Please ask for: Mrs D Johnson
Email: daun.johnson@arun.gov.uk
Telephone: 01903 737762
Our Ref: AL/27/20/PL
Your Ref:
Date: 20th April 2020

Application for Planning Permission

Development: Demolition of the existing dwelling & construction of 2 No. 2-bed, 3 No. 3-bed & 4 No. 4 bed houses including access, landscaping & associated works (resubmission following AL/51/19/PL).
Location: Springfield Hook Lane Aldingbourne PO20 3TE

Plot 2 and 3 Floor Plans 1:100@A3

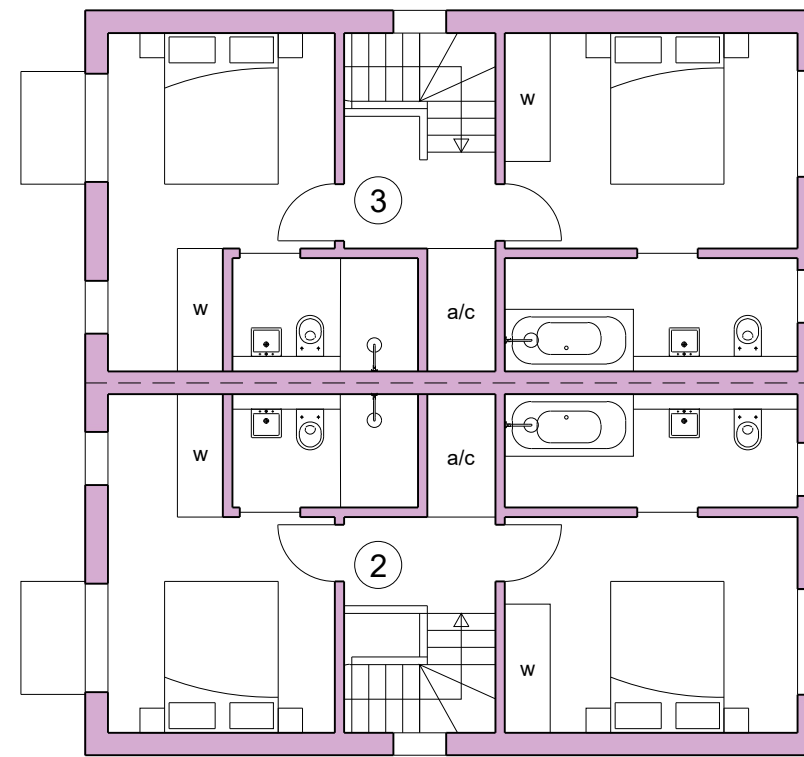
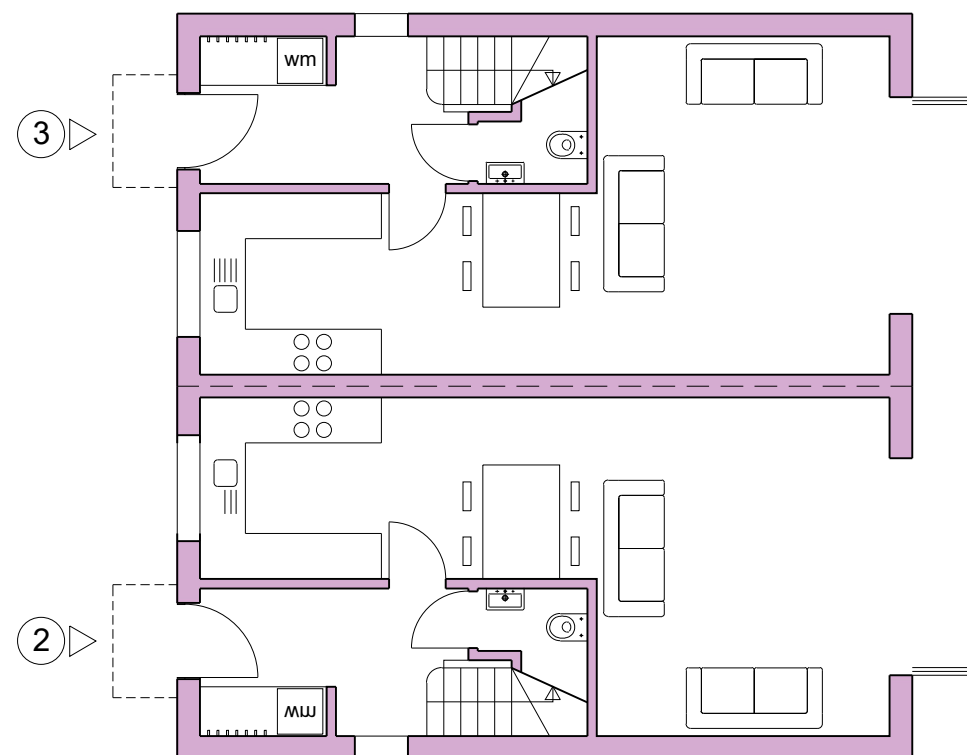
Please provide floor plans for plots 2 & 3.

Plot 6 Floor Plans 1:100@A3

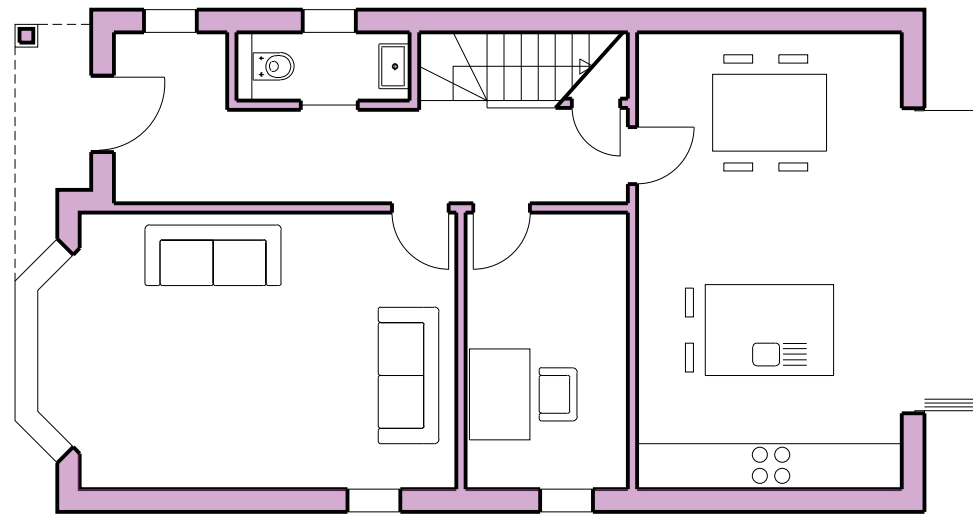
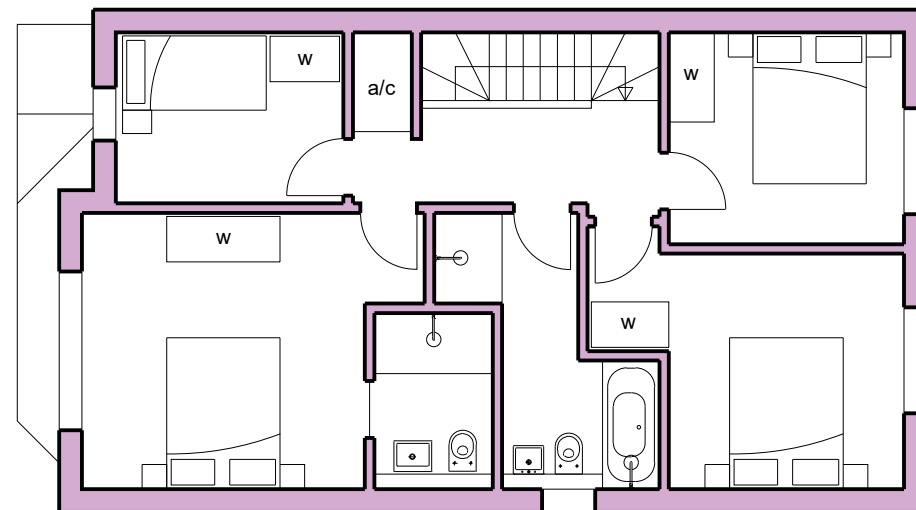
The floor plans have been labelled incorrectly for plots 6 & 7. Please amend accordingly.
